DESIGN PROFESSIONAL INSPECTION FORM

Residential Single-Family Project: Y N	Commercial Project: Y N
Code Enforcement Project No:	Permit No: SFD 2205-0005
Project Name: Residential Building 11 Willow Run	Owner: Lance and Megan Kappel
Project Address: 11 Willow Run Sanford, NC	Suite No: N/A
Date Inspected: 06/29 & 07/13 2022	Contractor Name: Harrington Properties of NC
Component Inspected: Foundation Observations

RE: Foundation Evaluation and Foundation Observations
Residential Building
11 Willow Run
Sanford, NC

**201 FOUNDATION PLAN**  
SCALE: 1/4" = 1'-0"

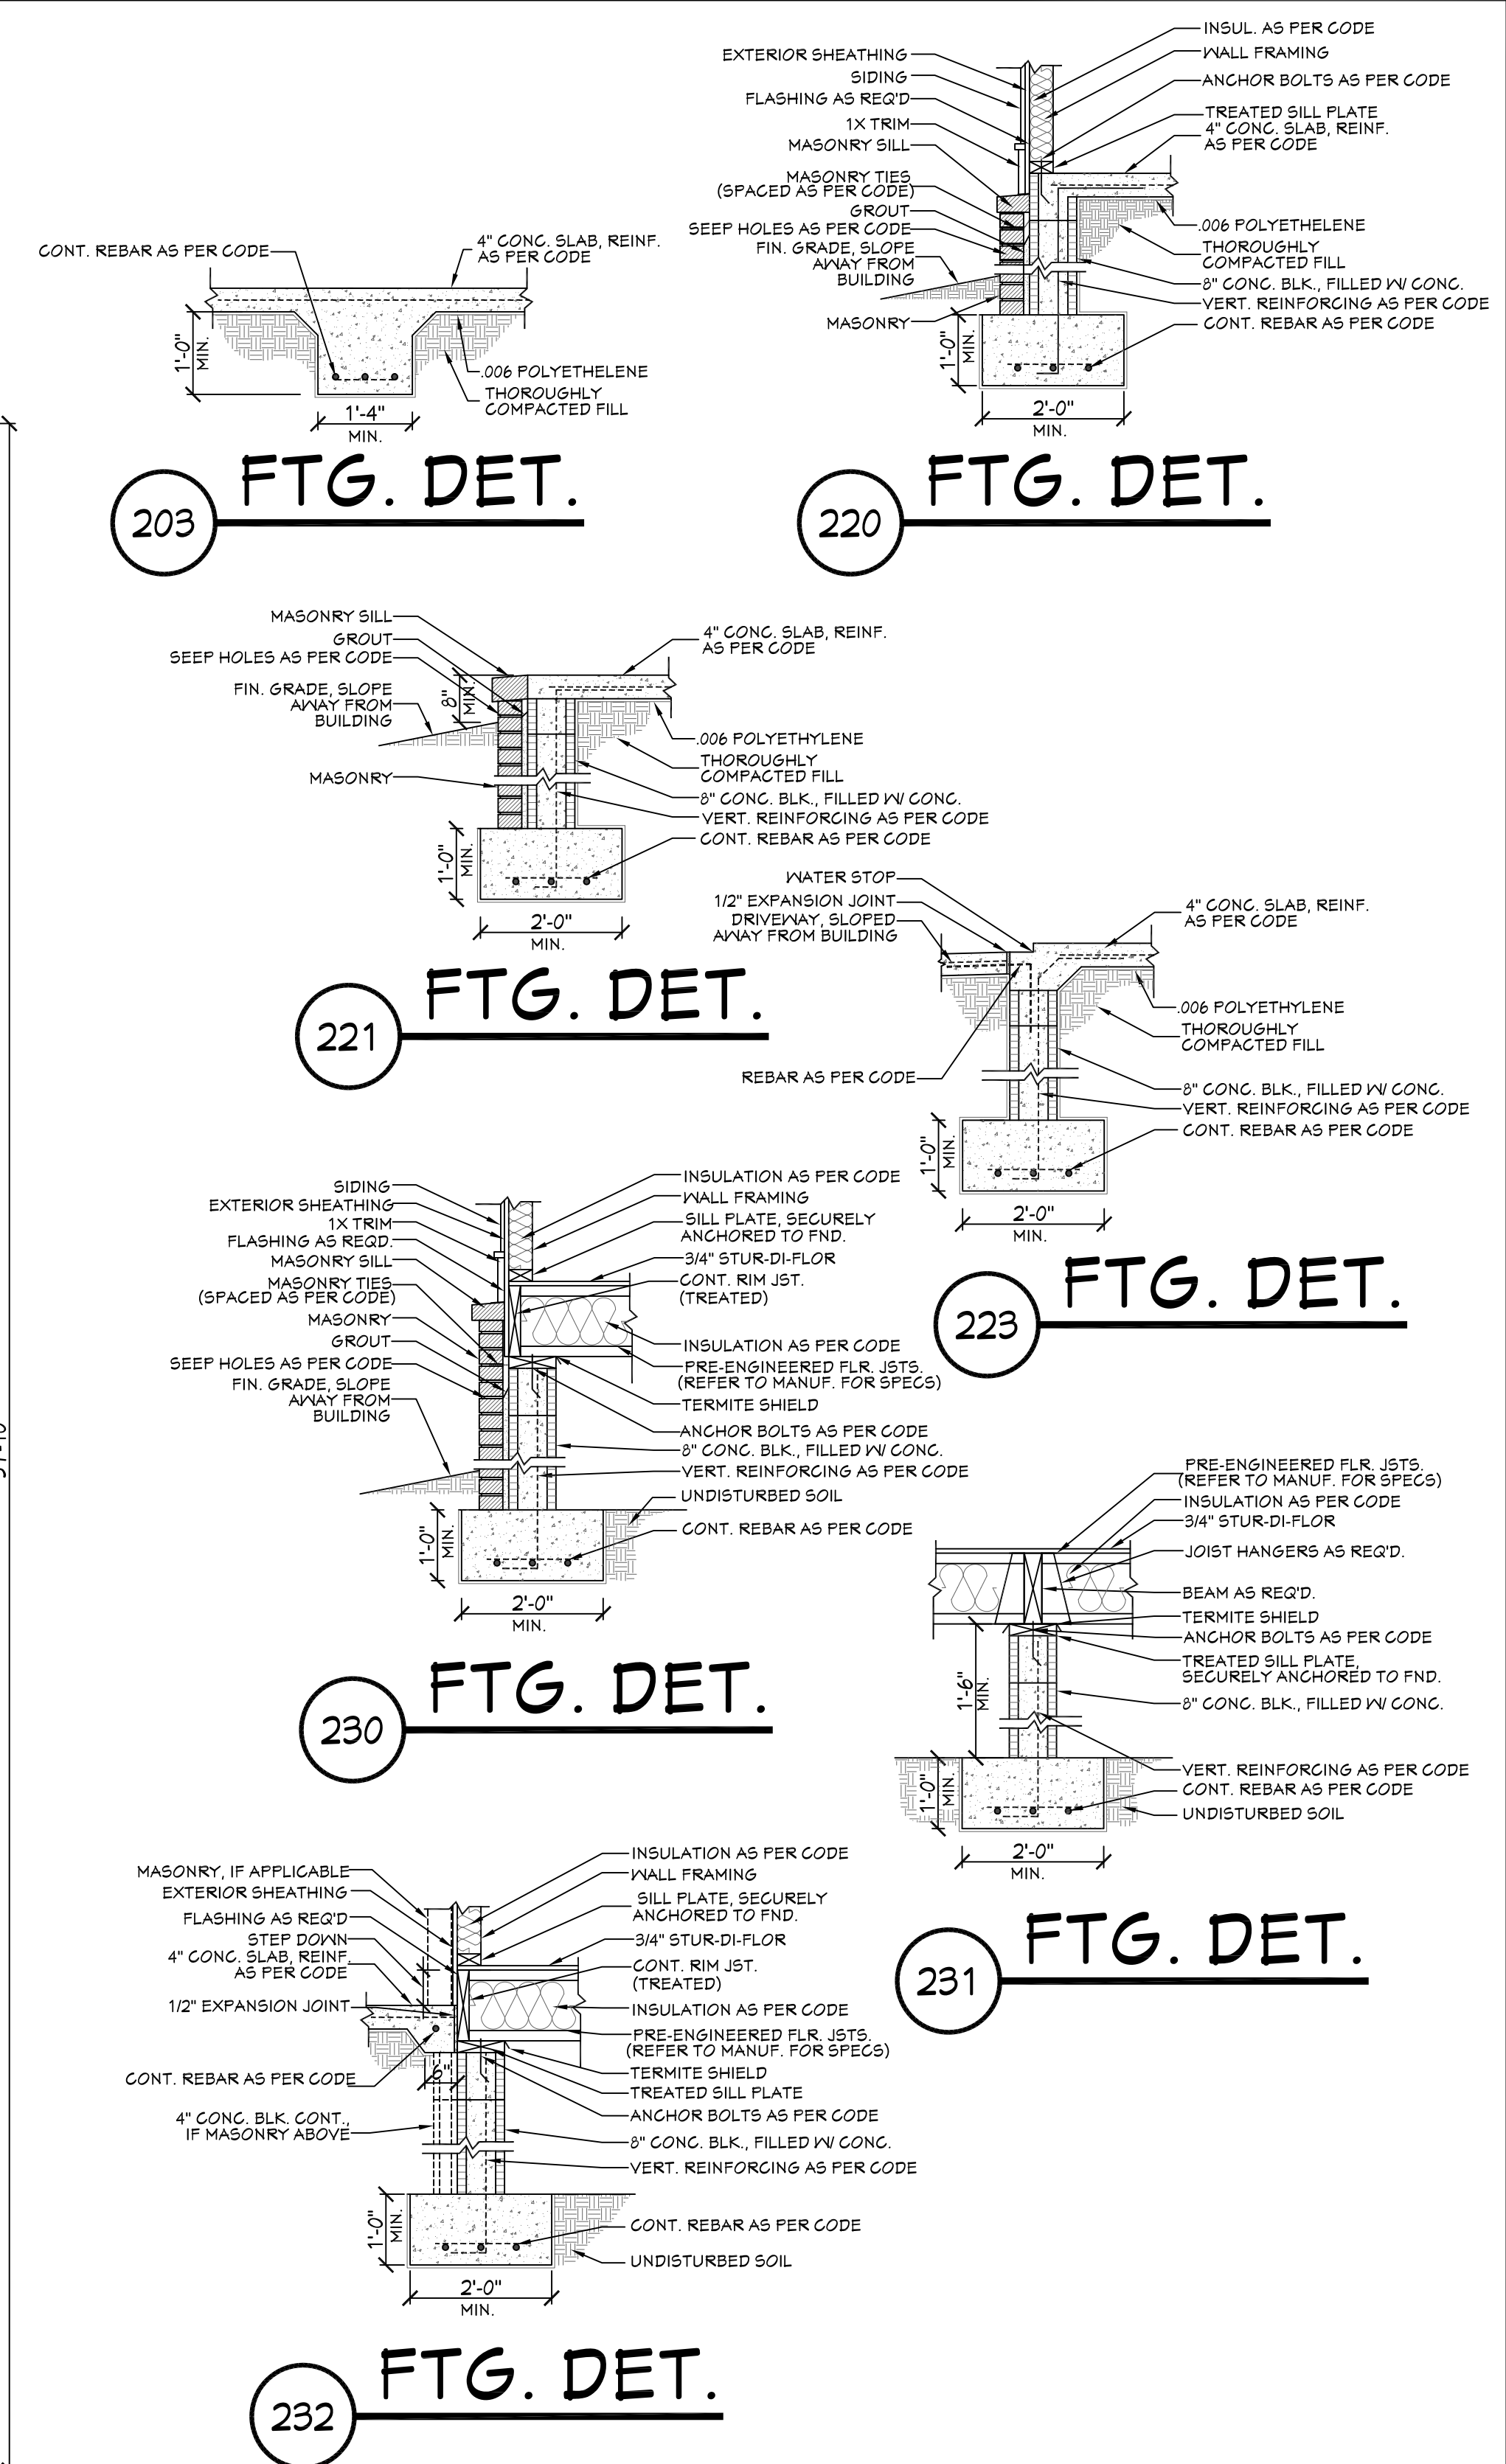
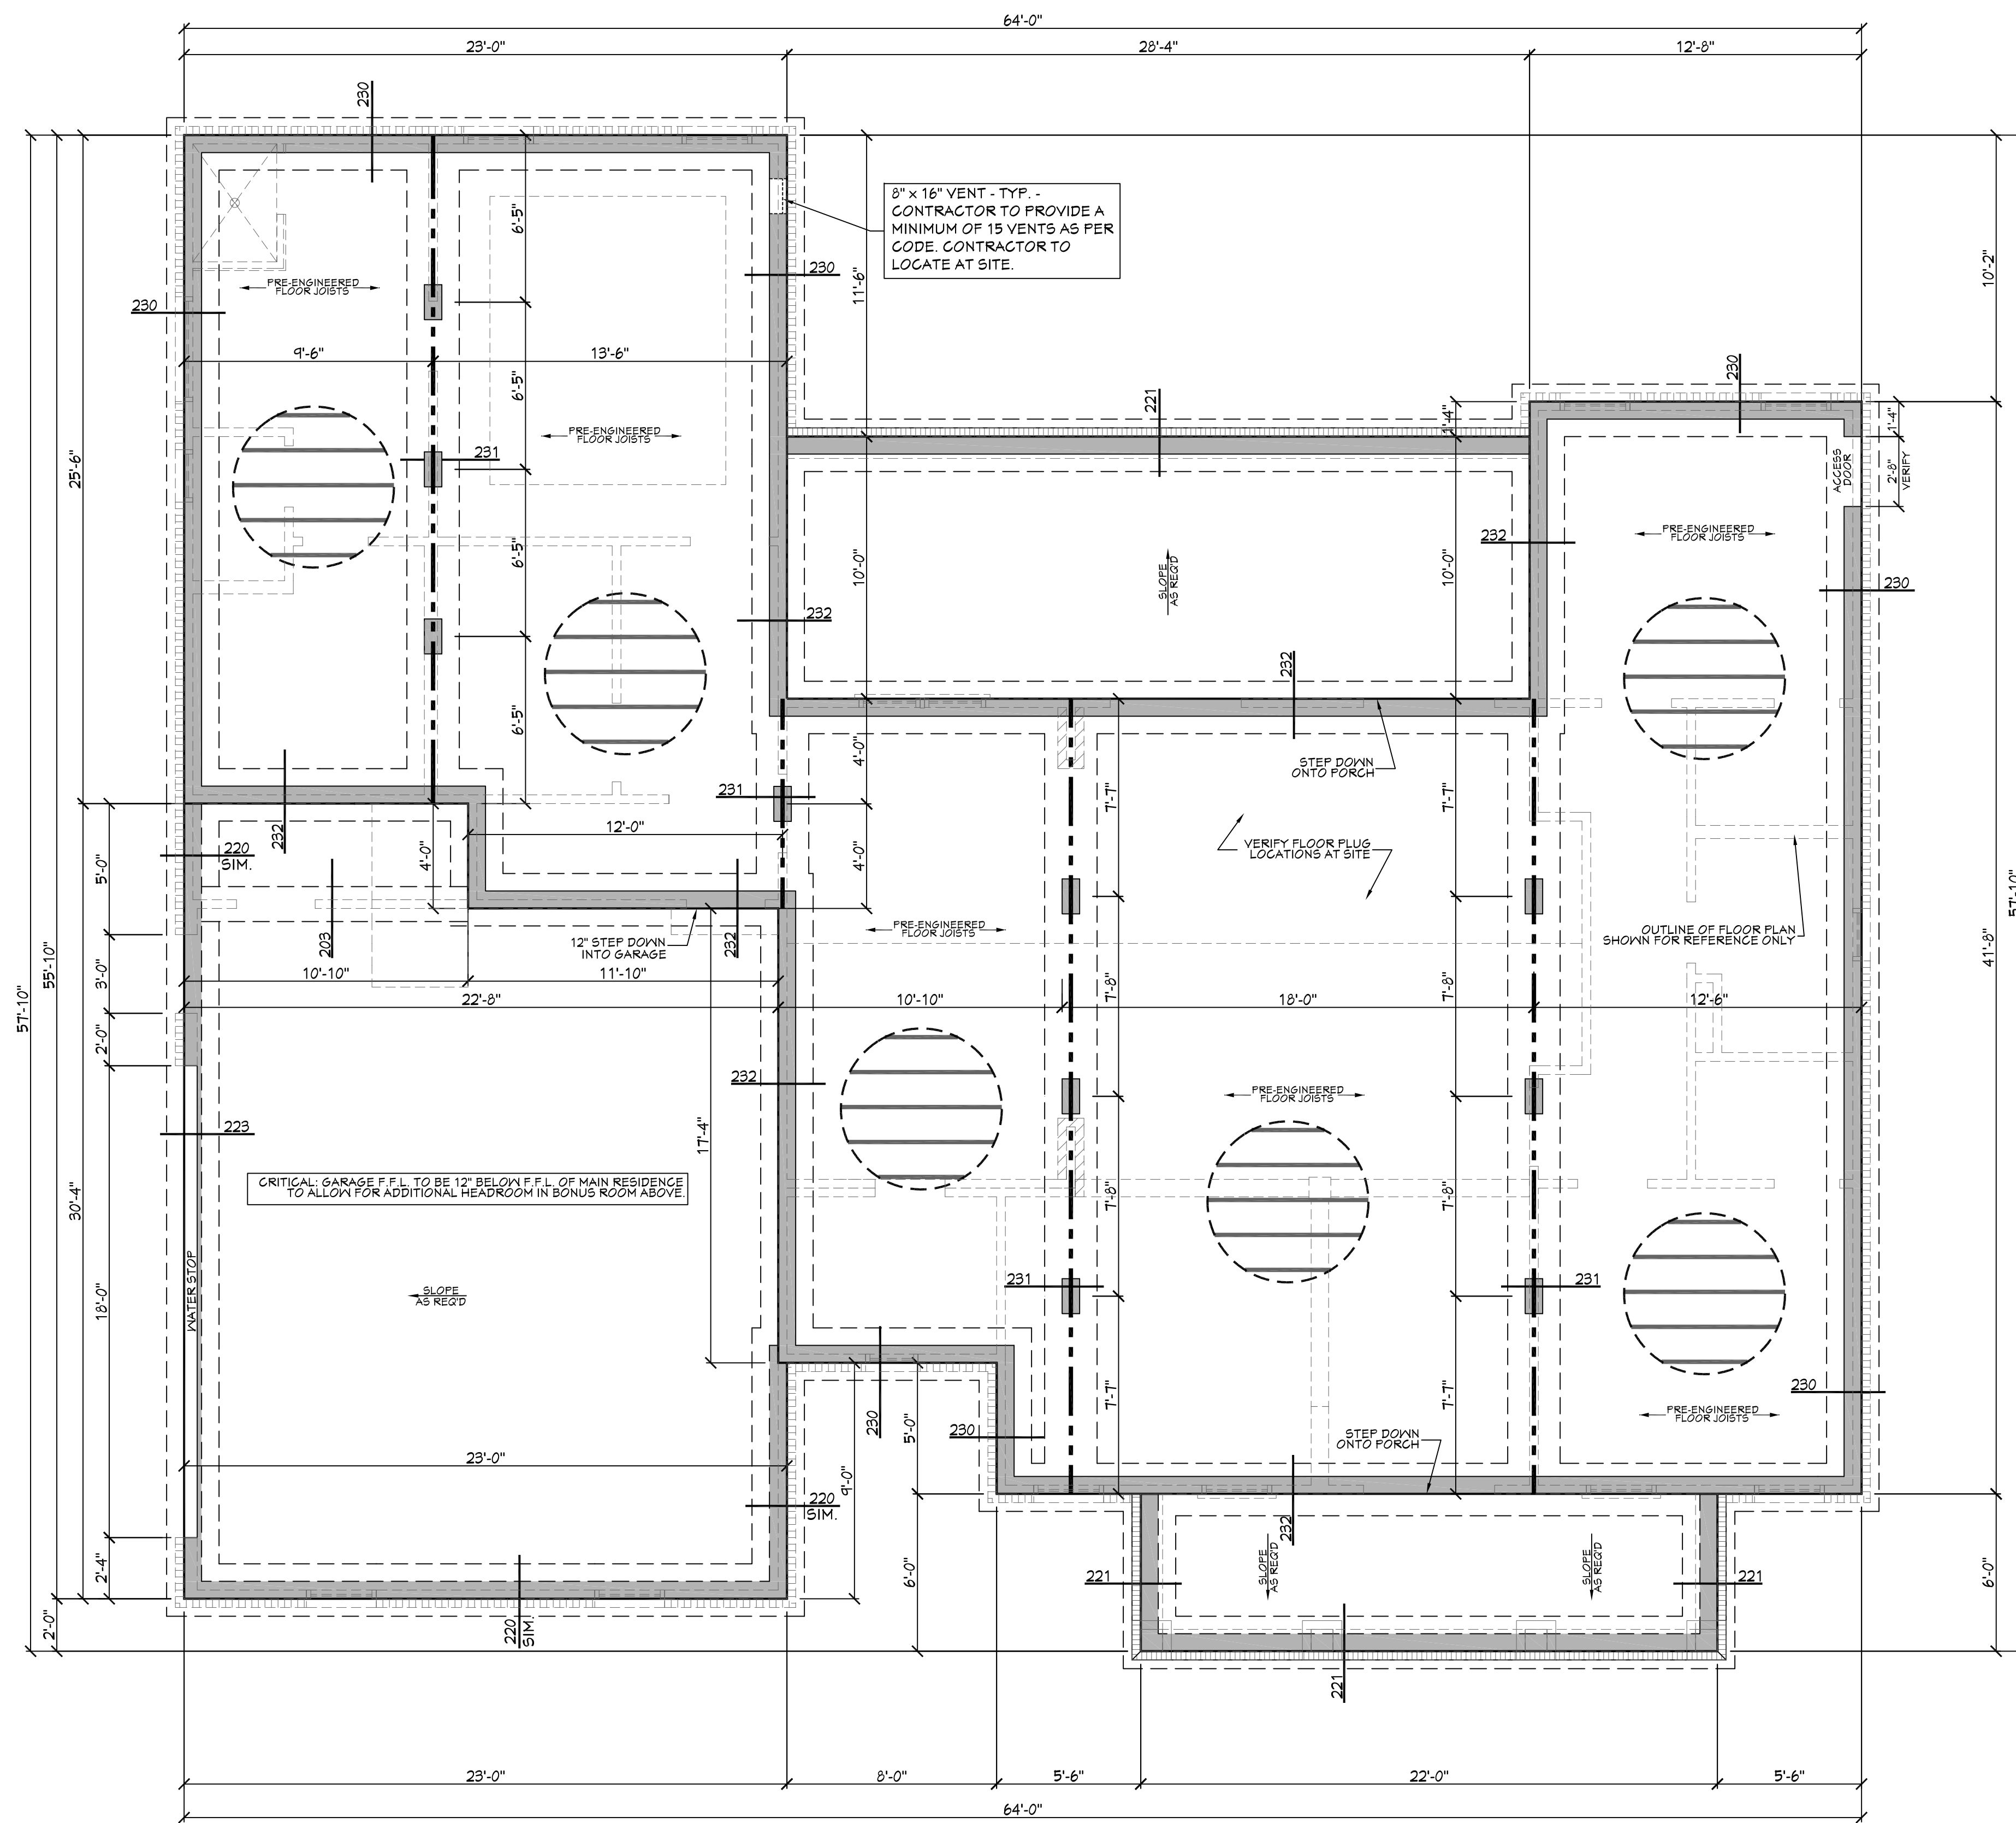
The building plans are by House Plan Zone, LLC dated October 11 2017 and are designated Pre-Drawn Plan ID BB-1988AR. The plans state that the foundations are to be reviewed by a structural engineer for compliance with the 2018 NC Residential Building Code. Based on my evaluation and comparison with the Foundation Plan (Sheet 2), I concur that the foundation widths and depths are suitable and the net foundation contact pressure is less than 2000 psf. However, the steel reinforcement noted on the details is not necessary and can be omitted.

On June 29 and July 13, 2022, the foundations excavations were observed. Soils primarily consisted of brown and gray brown sandy CLAY (CL) and clayey SAND (SC). At several footing locations soft soils were excavated and replaced with No. 57 stone. Dynamic cone penetrometer readings ranged from 6 to 11 blows per increment. The exposed foundation soils have at least 2000 psf bearing capacity. The footing excavation depth, width and length, matched the Foundation Plan by House Plan Zone, LLC, and the interior column footing plan requirements per my evaluation.
